Pre-Application Meeting (PRE21-041)

Site Location:	2841 60 th Ave SE	Parcel Number	217450-2780
Lot Size:	13,980 square feet	Zoning:	R-8.4 (Single Family)
Brief Project Description:	A proposal to install a new boat lift	Documents Provided:	1. Pre-Application Meeting Request Form 2. Project Description & Construction Sequence 3. Plan Set
Applicant Information:			
Name:	Amanda McIntosh	Email:	amanda@waterfrontconstruction.com
Phone:	206-548-9800		
Second Pre-application Meeting Required:	Not Applicable	Click for explanation if necessary

August 24, 2021

PROPOSED SITE PLAN

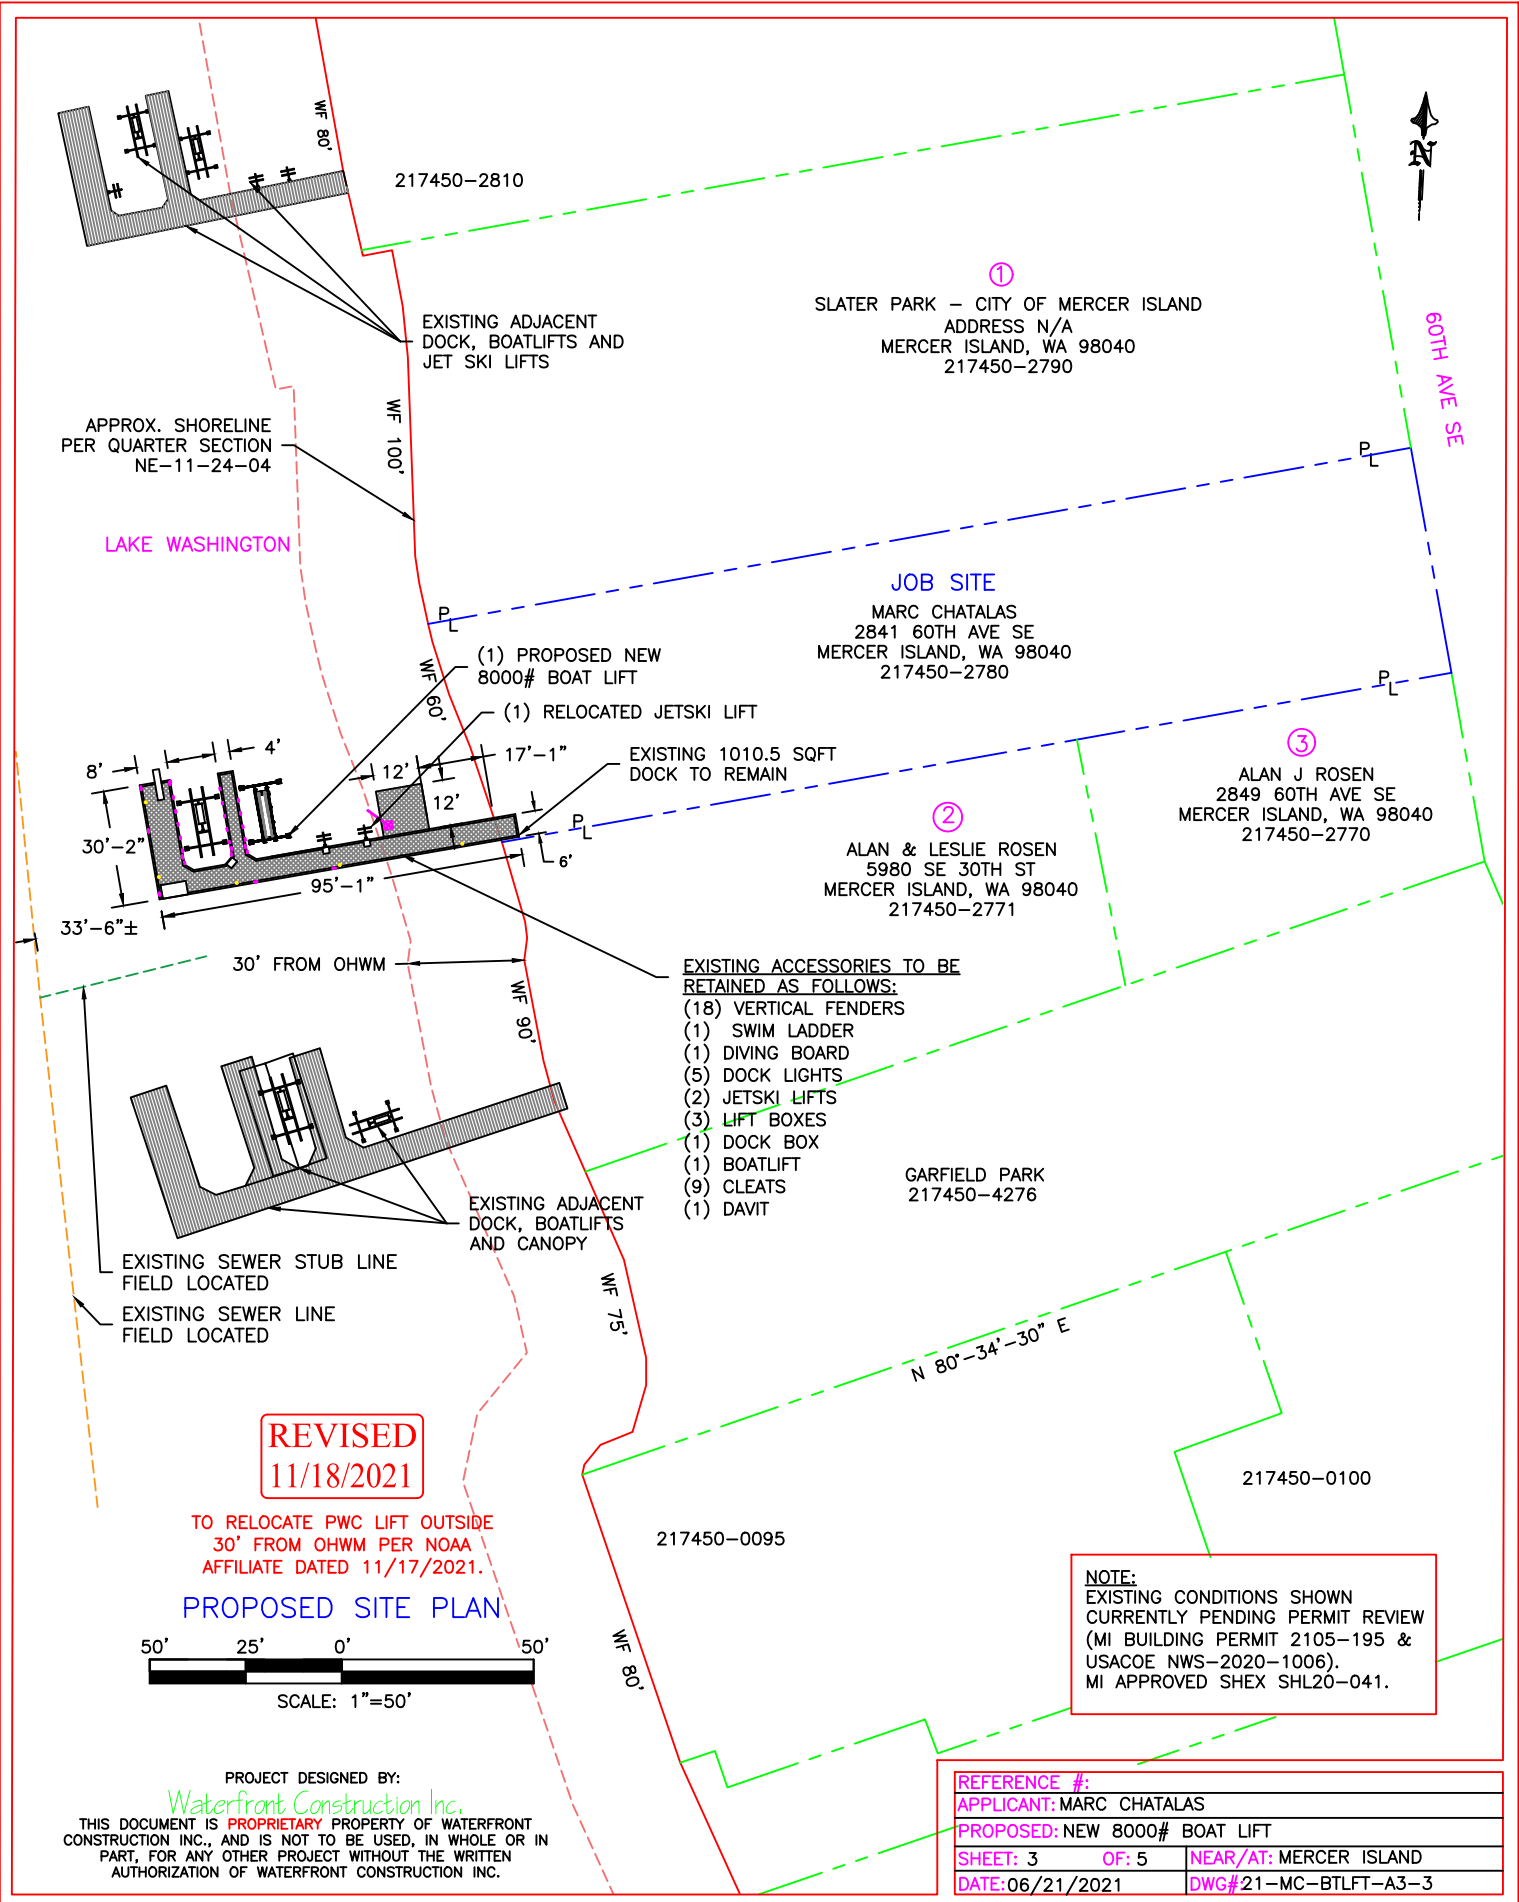
1. Lakebed supported boat lifts do not require a building permit. Other permits may be required for installation, such as plumbing or electrical permits.
2. The shoreline application references building permit 2105-195, but that application does not address the relocation of the jet ski lift. The jet ski lift is regulated under the dock building permit since it is attached to the dock structure.

- iv. Only dock, ramps, and boatlifts may be within the first 30 feet from the OHWM. No skirting is allowed on any structure.
 - v. The height above the OHWM for docks shall be a minimum of 1.5 feet and a maximum of 5 feet.

4. Easement:
 - a. Sewer Lake Line Easement
 - i. The sewer lake line will need to be field located before final building permit approval.
 - ii. A sewer lake line affidavit will need to be submitted prior to building permit approval.

PROPOSED DETAIL VIEW

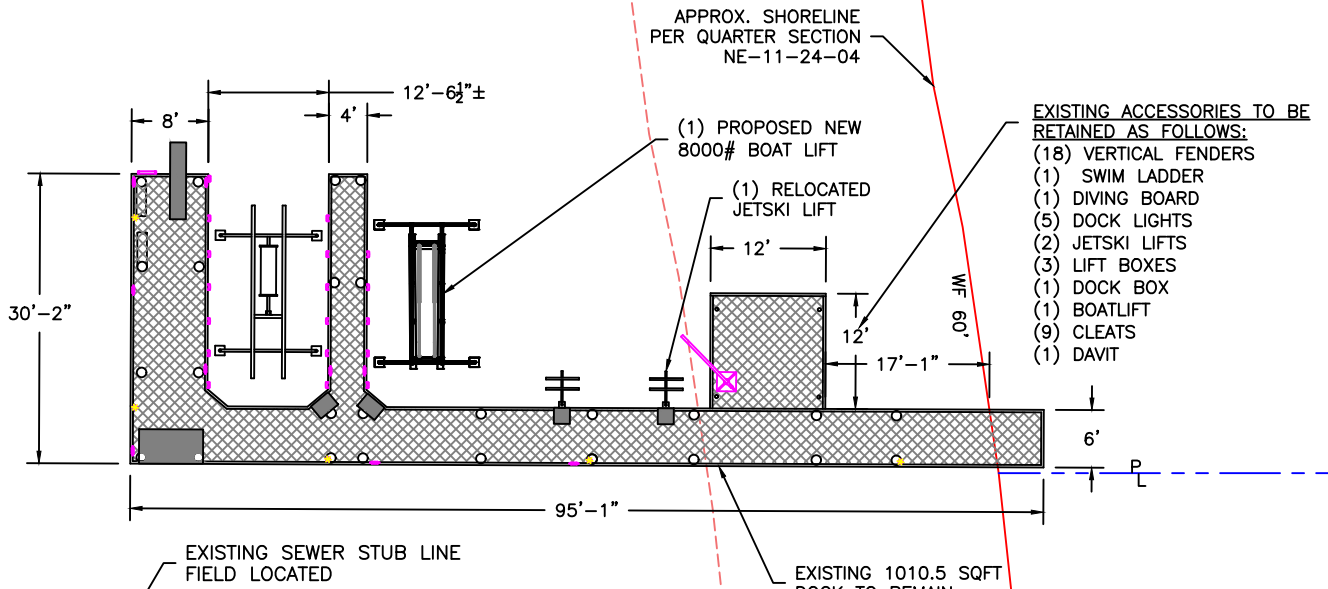
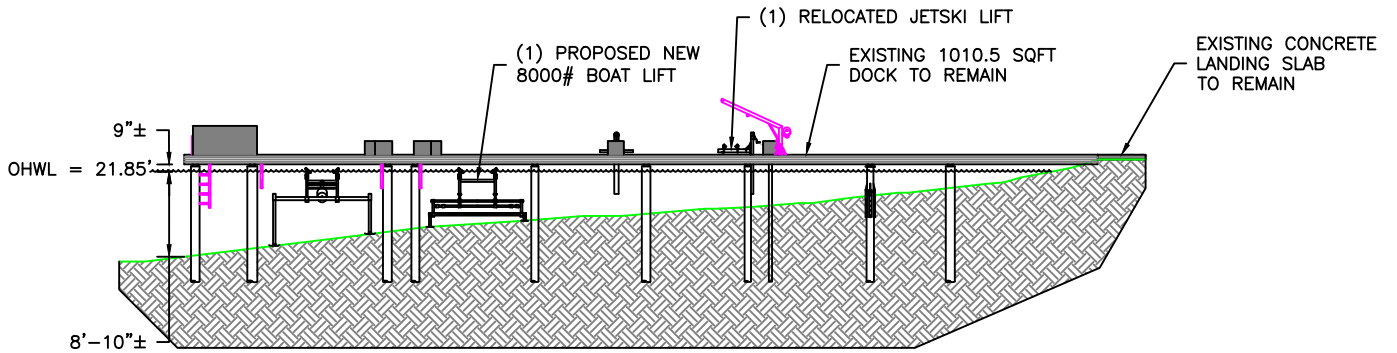
- a. This project involves the addition of a boatlift, which qualifies as an expansion to an existing moorage facility. MICC 19.13.050(F) states that all permits for new and expanded moorage facilities, other than public access piers or boardwalks, shall meet the following standards unless otherwise exempted. Moorage facilities have the option of meeting either the development standards prescribed in MICC 19.13.050(F)(1) or the alternative development standards in MICC 19.13.050(F)(3)
